Our ref: LS/23716SPAB/13
Application ref: 3/2013/0012

29th January 2013

BARN ADJACENT TO ROCK HOUSE, TOWN END, SLAIDBURN

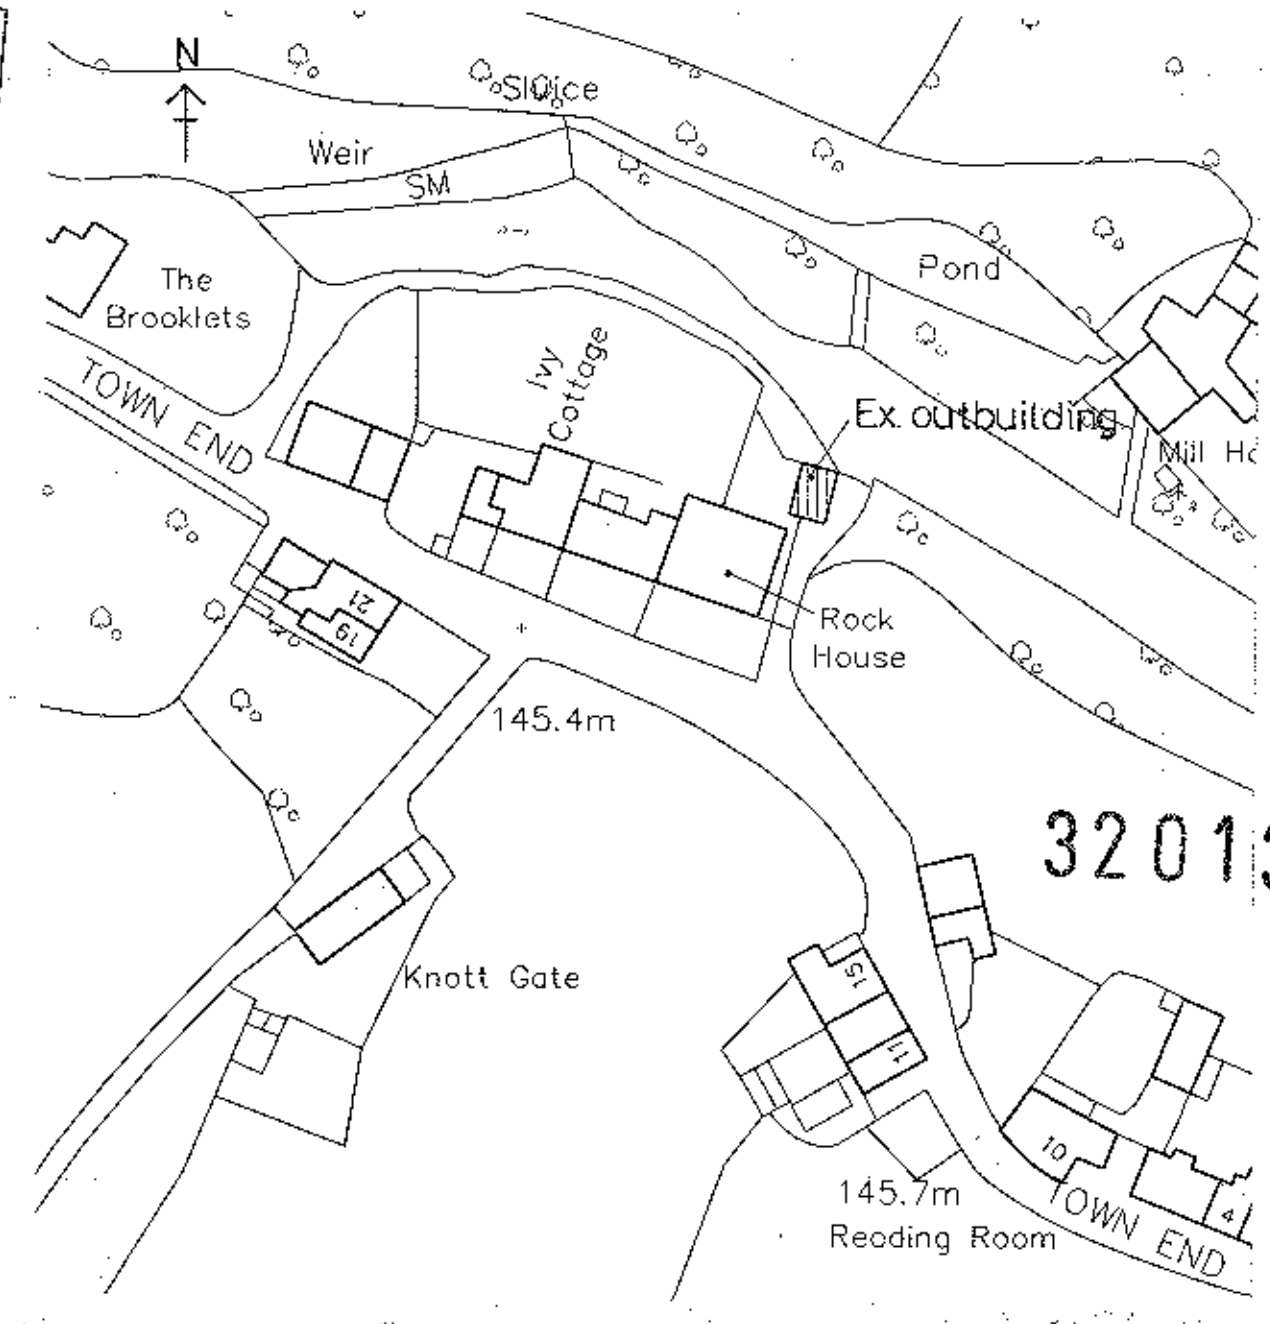
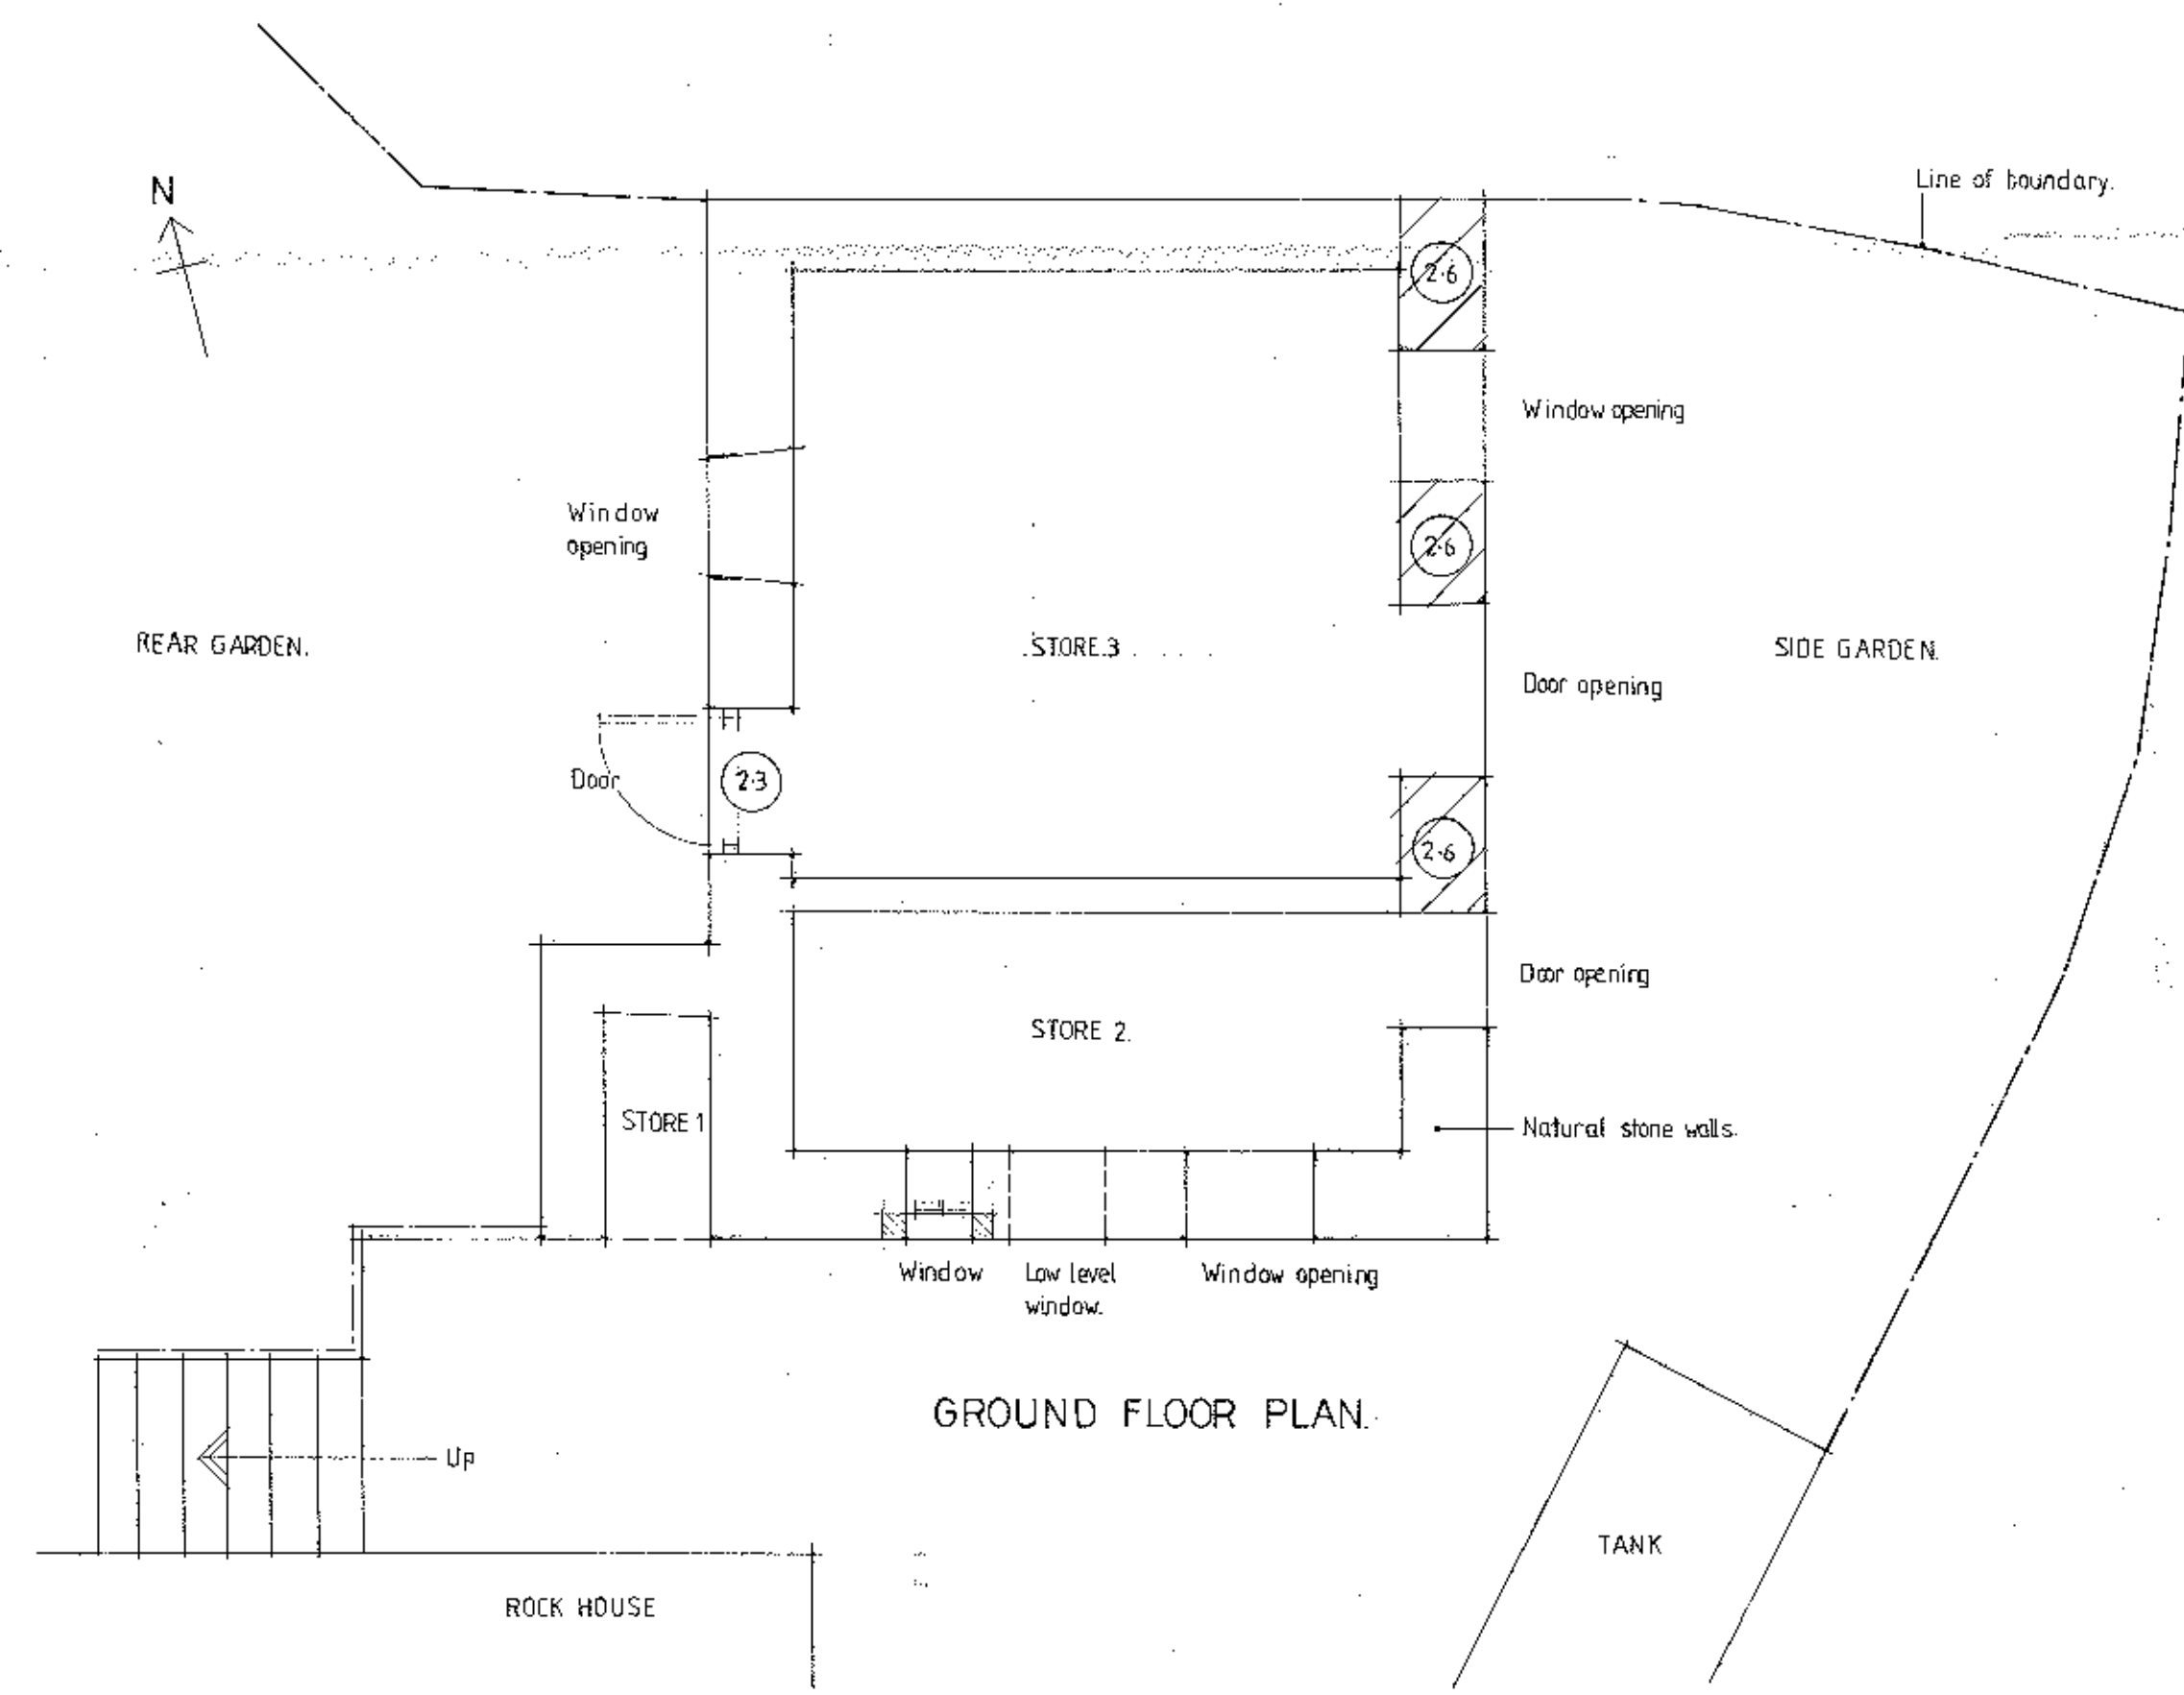
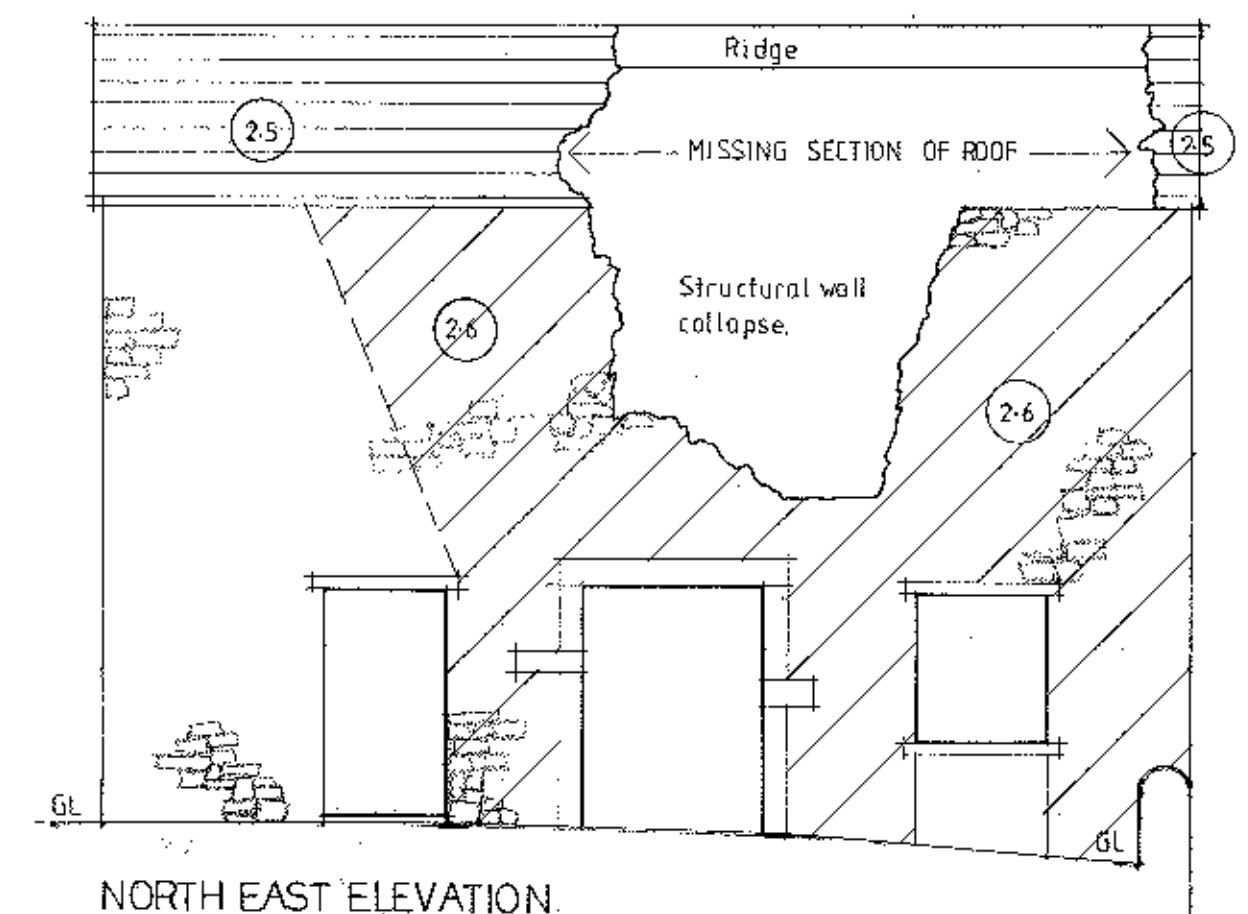
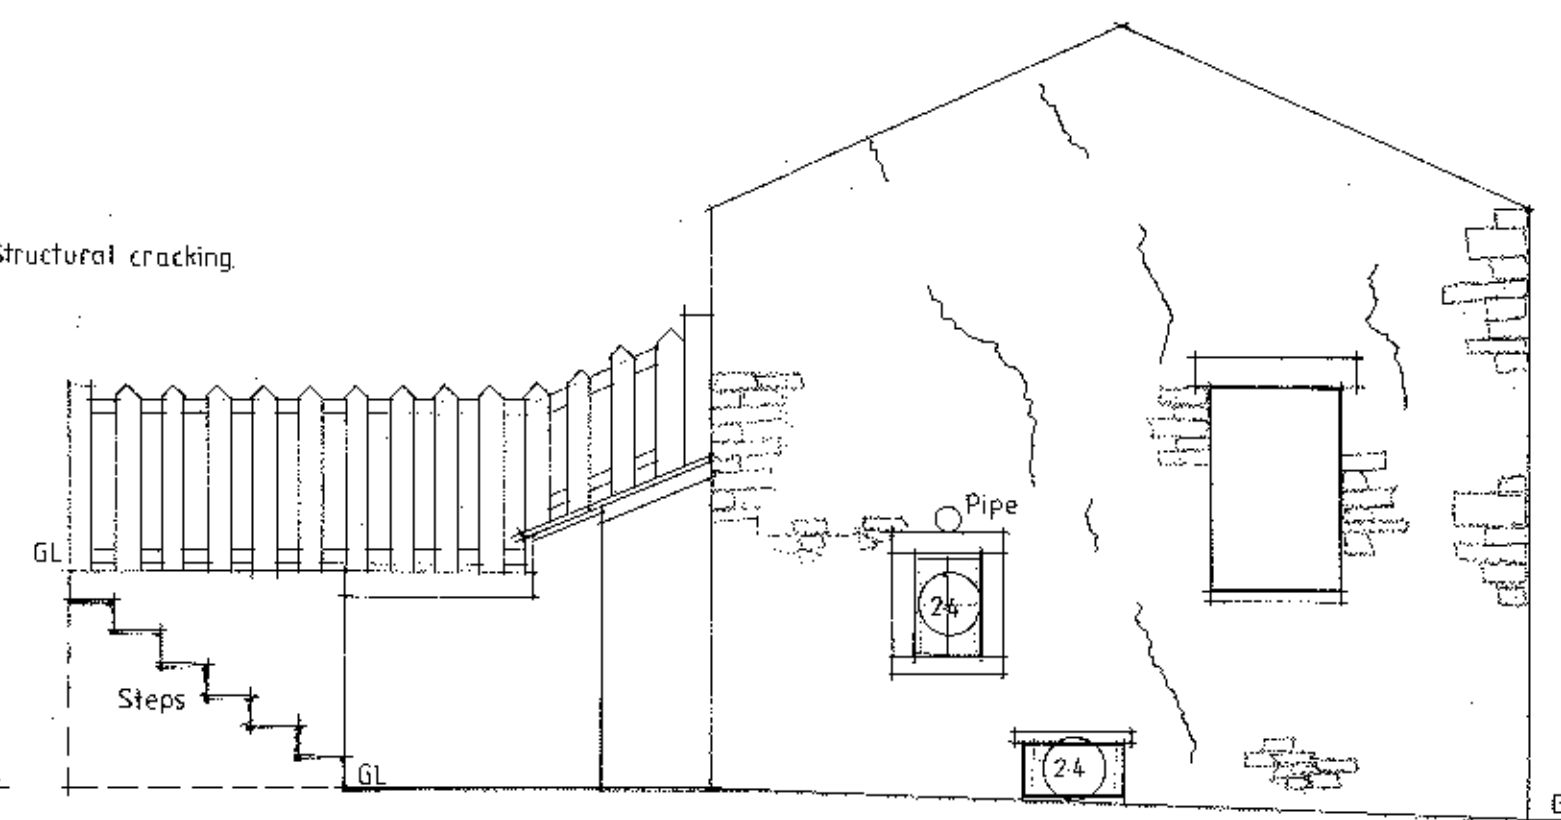
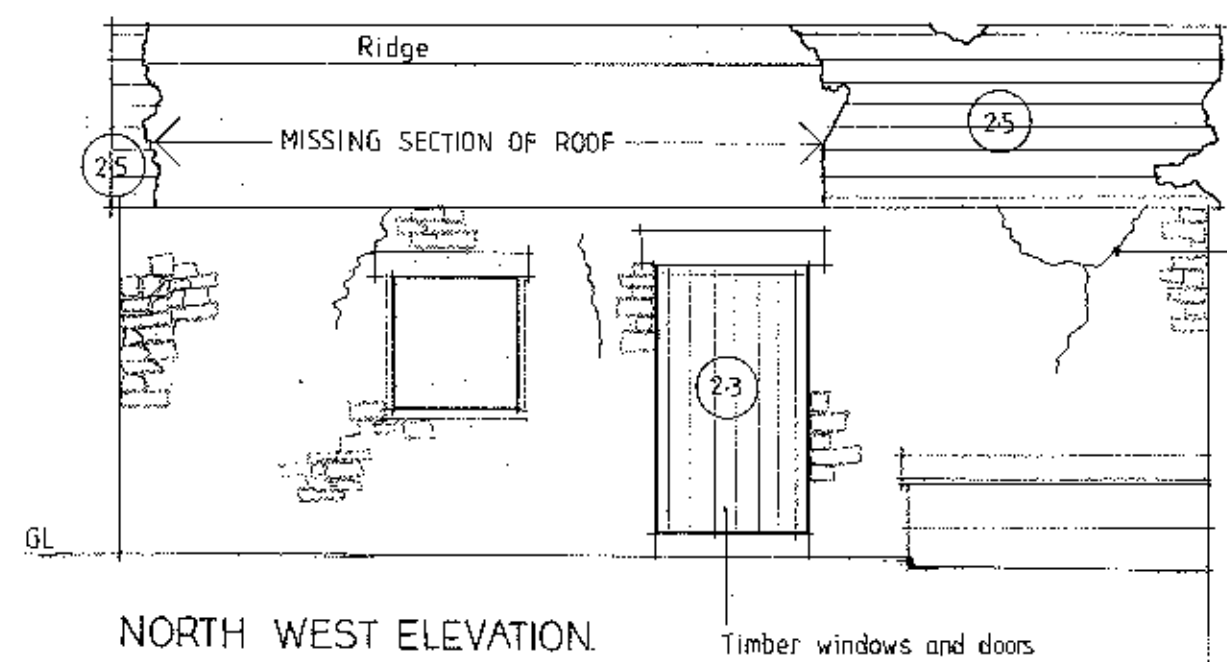
Extent of rebuilding: This is not made very clear in the drawings, and supplementary photographs to support the extent of rebuilding should be requested as a matter of principle. We remain to be convinced that such substantial quantities of walling need to be taken down as is suggested in the specification, and this requires further justification on the part of the applicant.
